18884 and 19004 Hilltop Pines, SF-19-016

Please accept the following comments from El Paso County Public Health for the project referenced above:

as replatted:

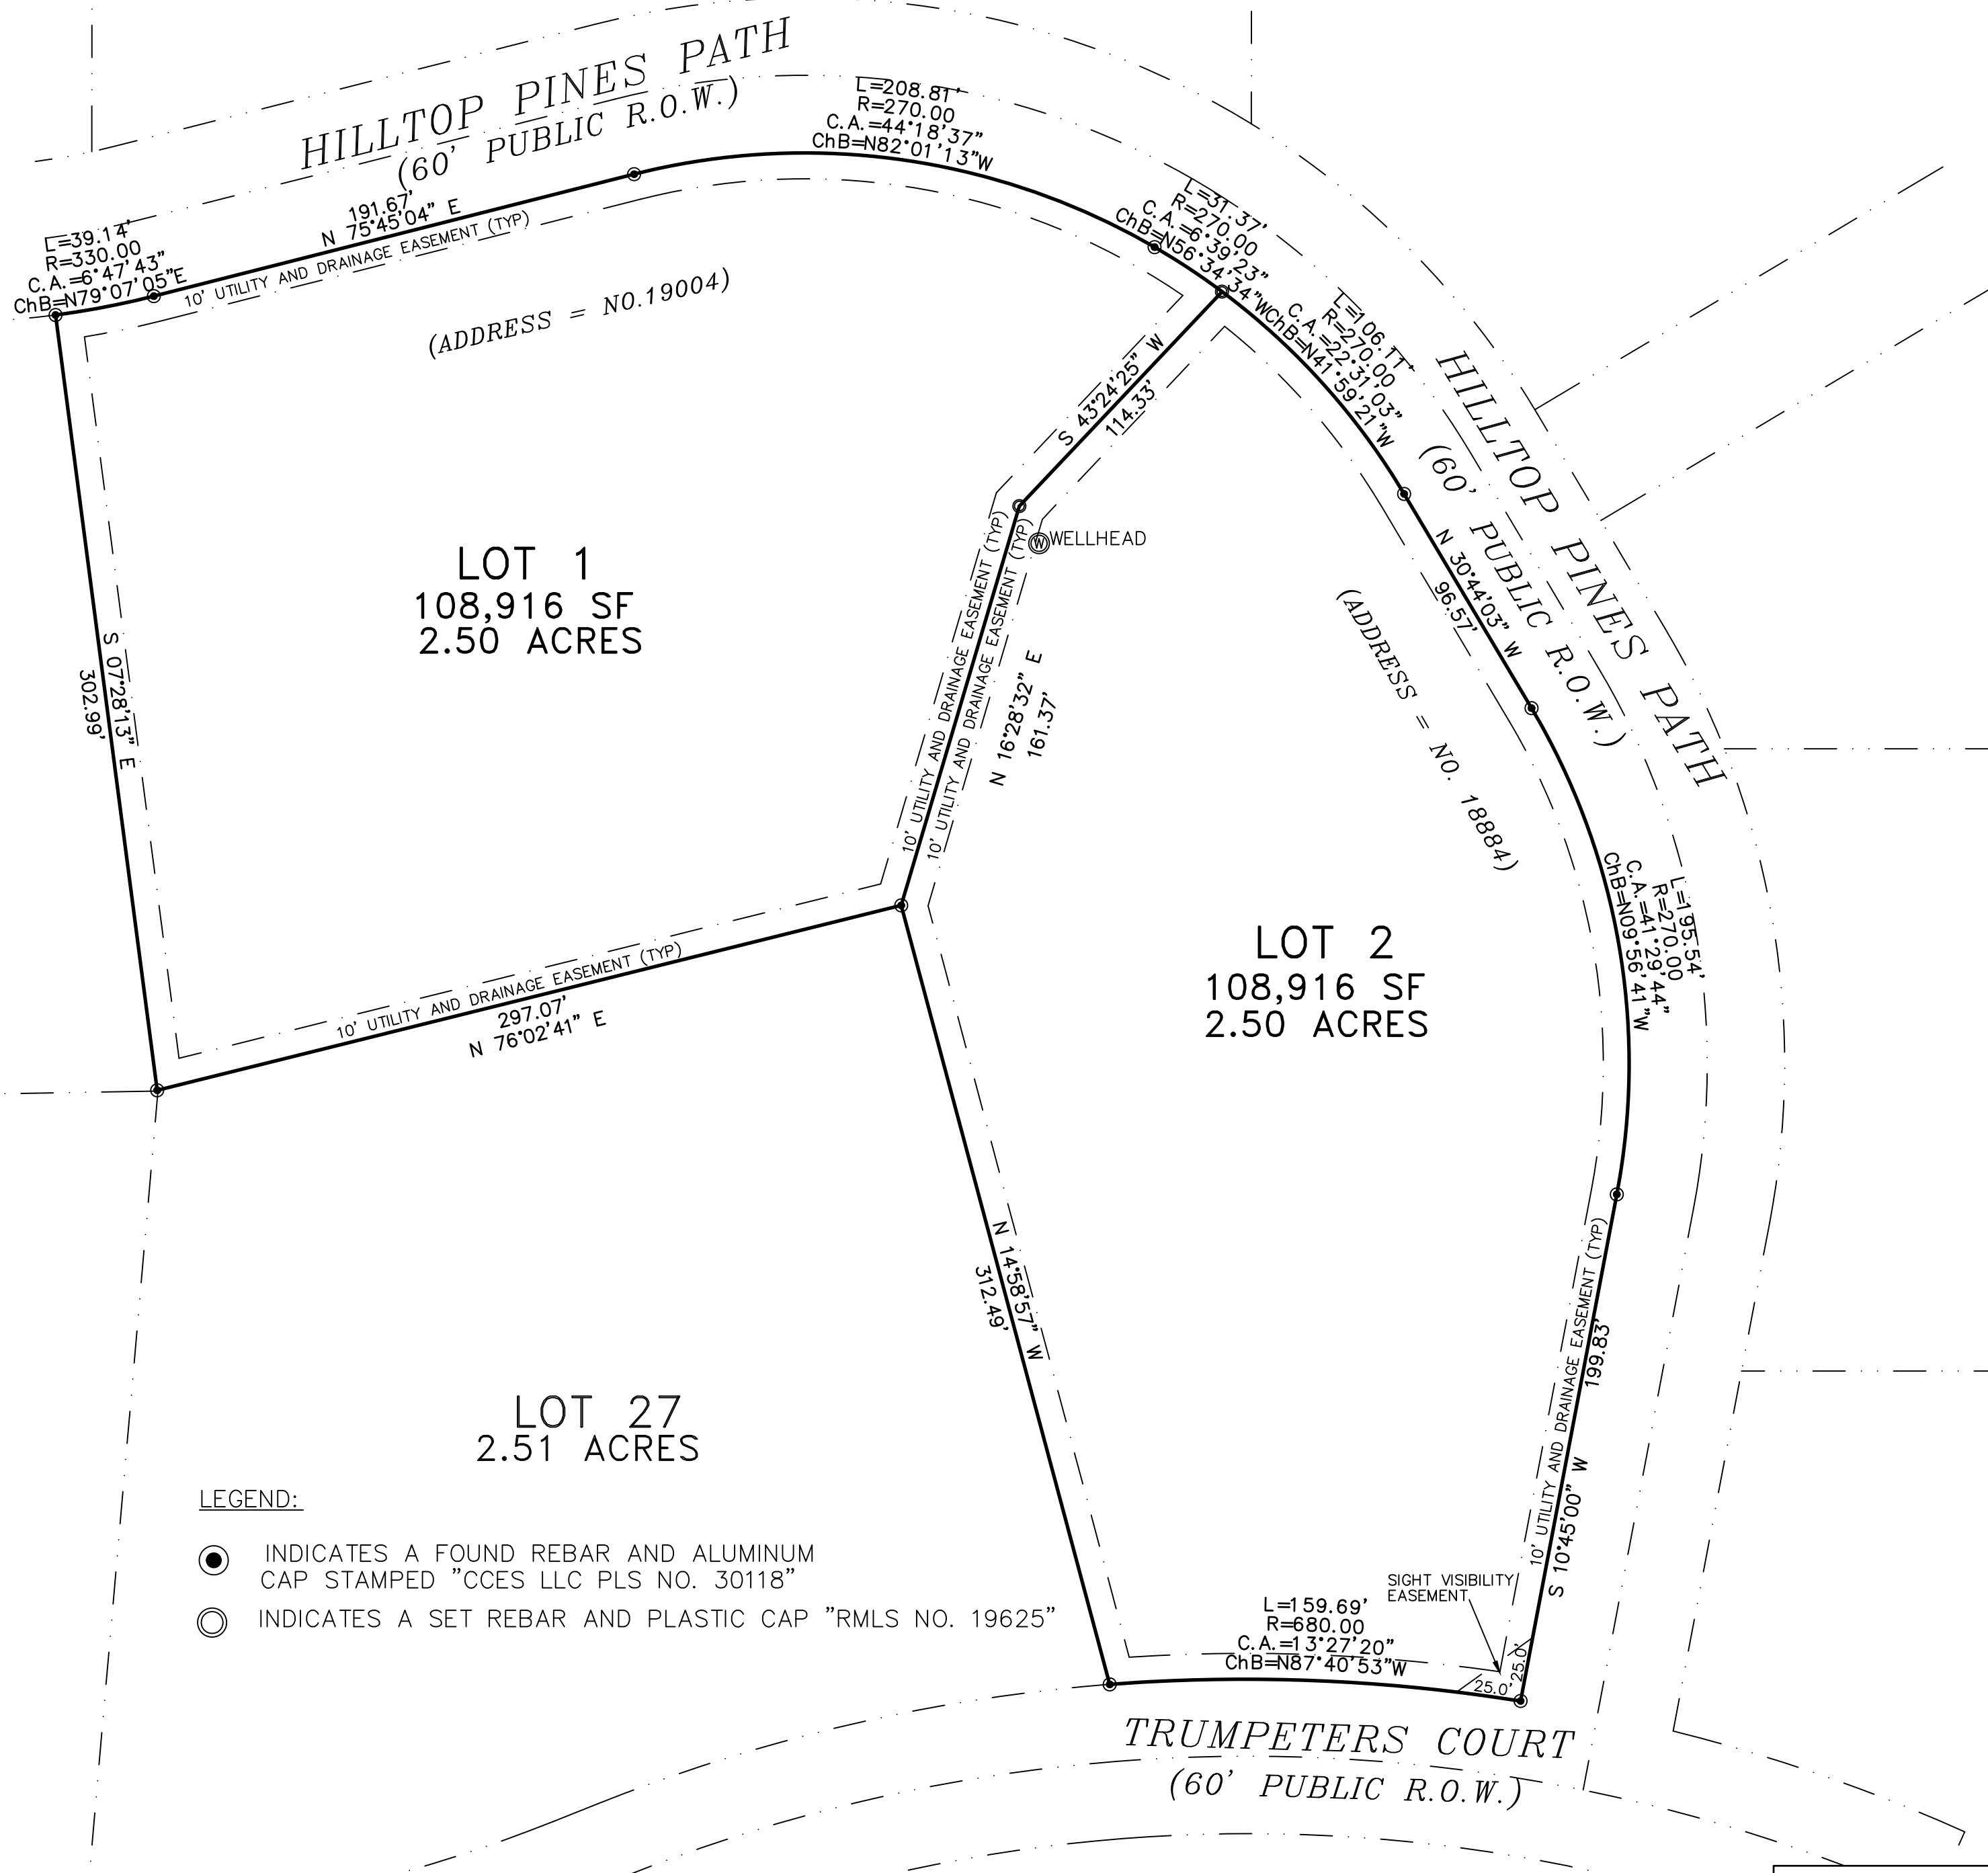
- There are no known public health issues identified with the lot line adjustment.
- Be aware future onsite wastewater treatment systems (OWTS) soil treatment areas on both lots must be a minimum of 100' from this well and any other surrounding well. Placement of a future well and OWTS on Lot 1 requires more critical planning.
